Application M/56/15/HH

31 Sea Way, Middleton-On-Sea, West Sussex, PO22 7RZ

We object to the plans under consideration at the above property. We moved to the estate in 1999 and have seen this house which is directly opposite ours change from a small, character cottage to an ever expanding structure, most of which is 'new build'. It is the equivalent of having two properties on the original plot. The character of the road at this point has already been unacceptably altered, including the addition of what seem to be large UPVC gates, and further overdevelopment must not be allowed.

Proposed Elevations  
Sections B-B  
C-C  
D-D

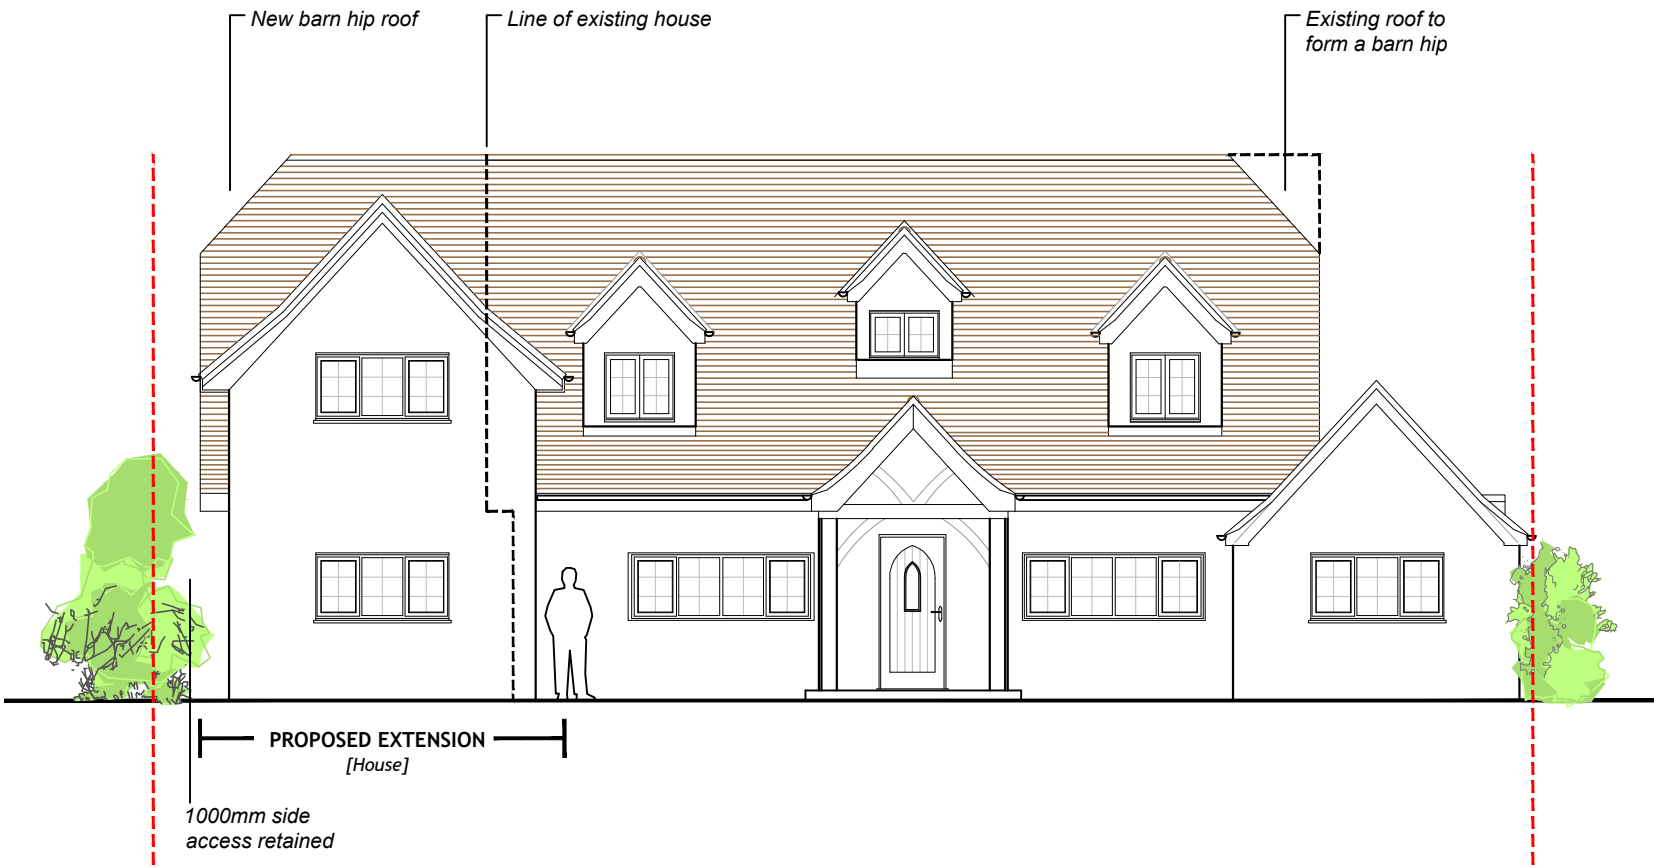
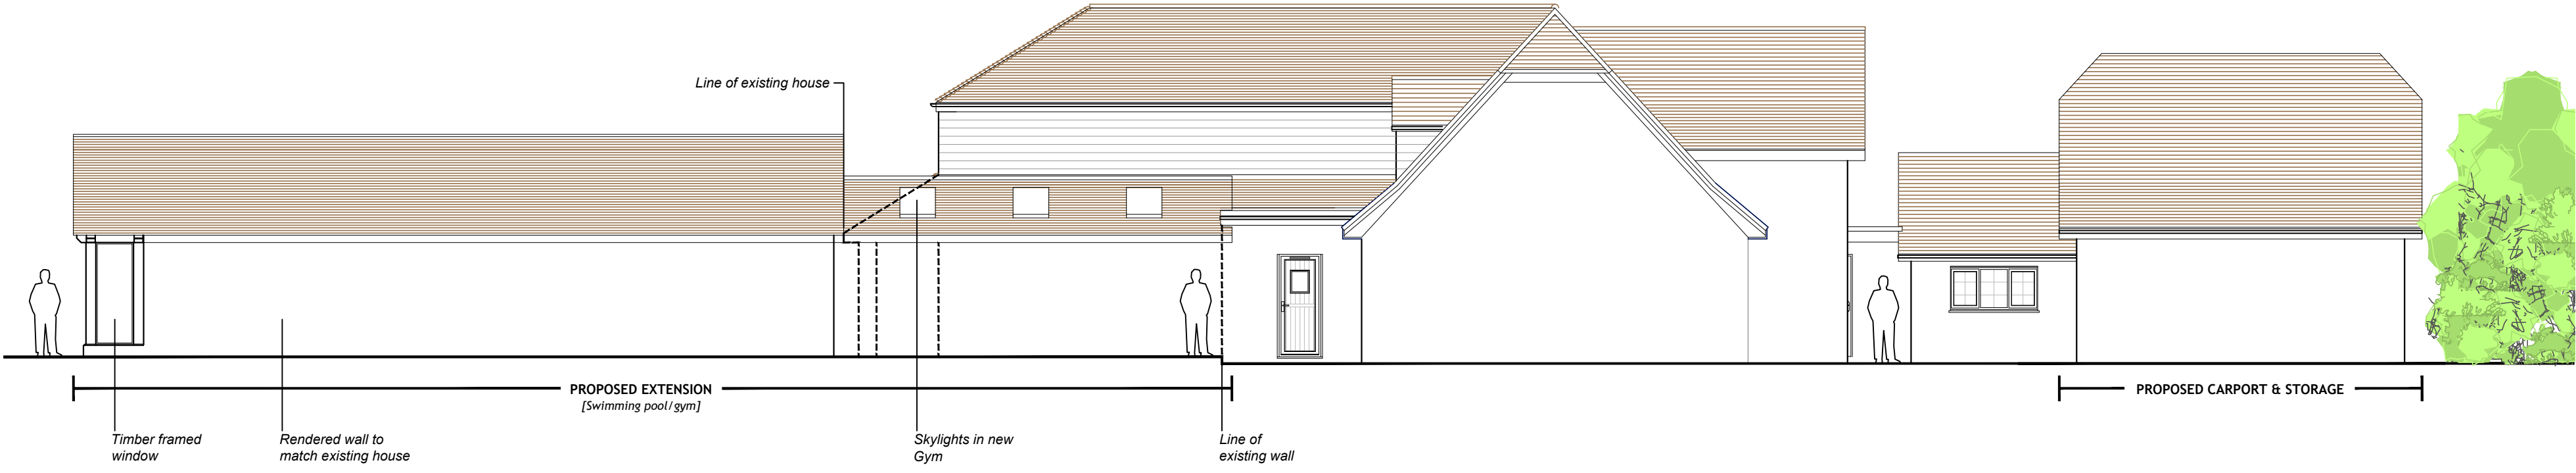
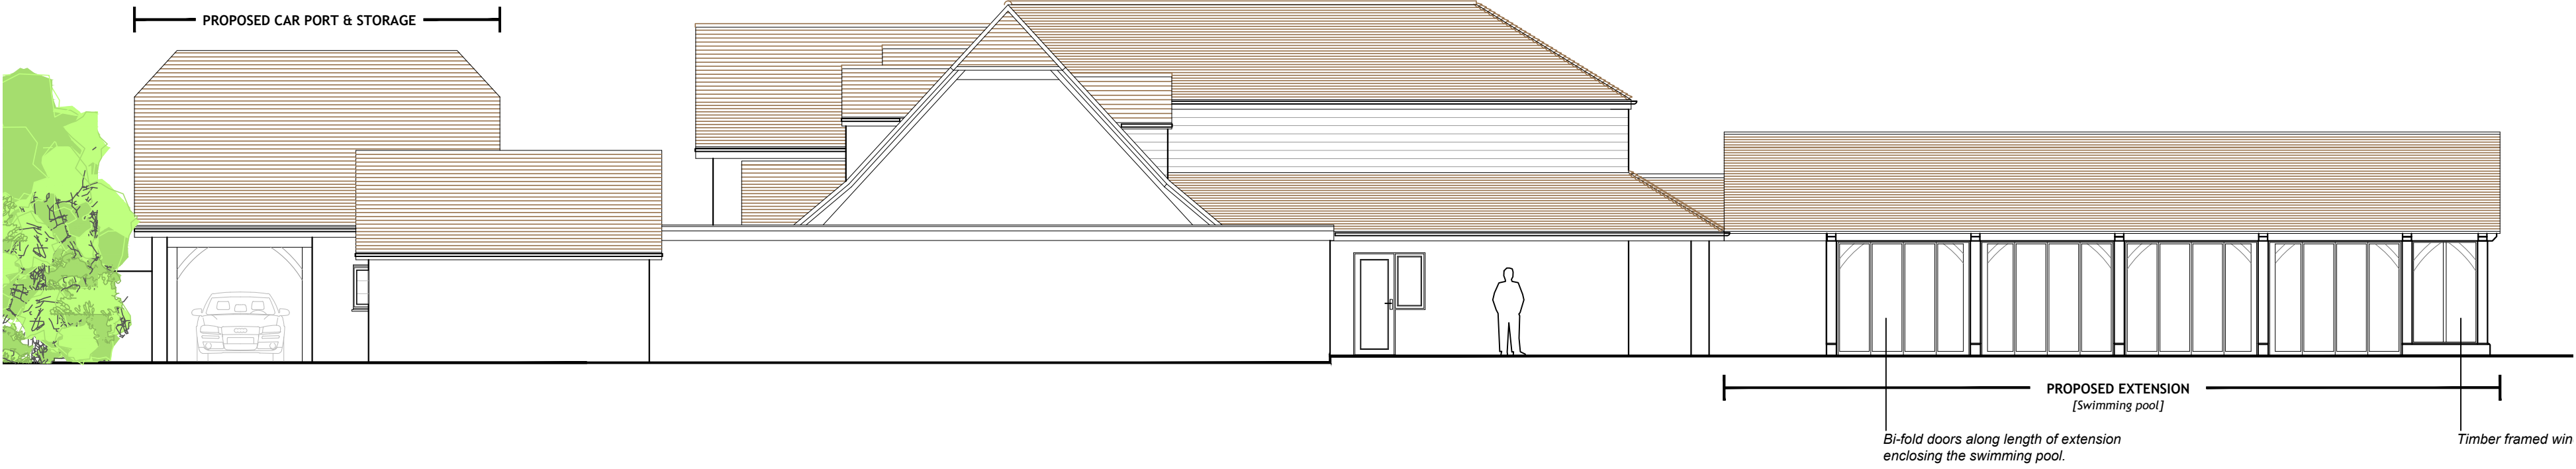
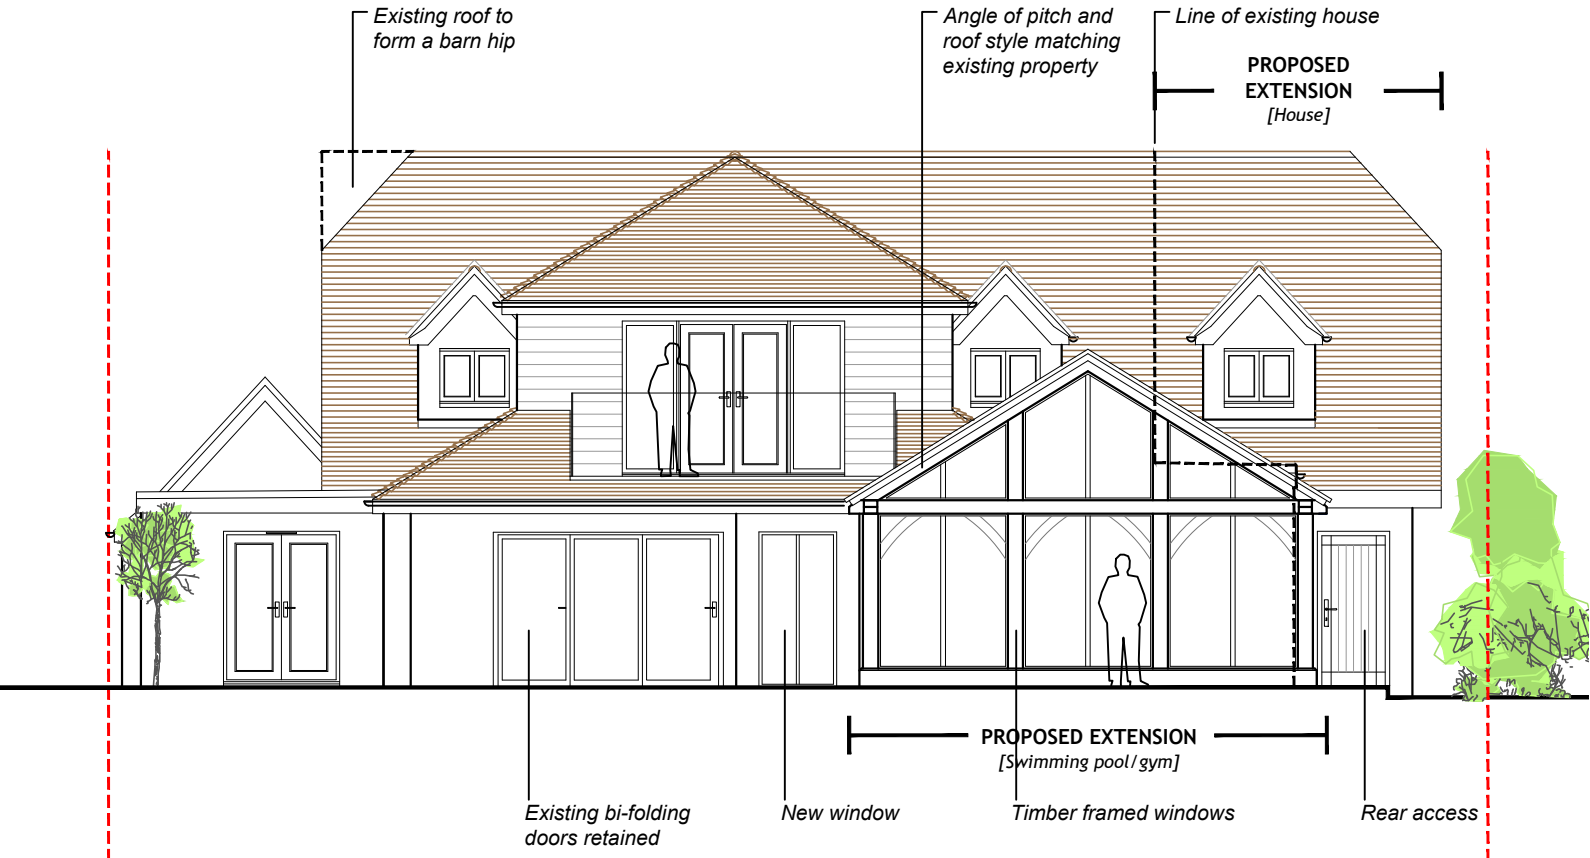
The roof space allowance suggests a possibility of conversion to living accommodation. Given the owner's record of maximising the living space at 'The Little House' (the irony), we would suggest that this will be either possible or more likely, inevitable. When we applied for planning permission the plan to have an upstairs utility room led to an unequivocal refusal to anything that could be used as an annexe or independent living space. These plans invite that.
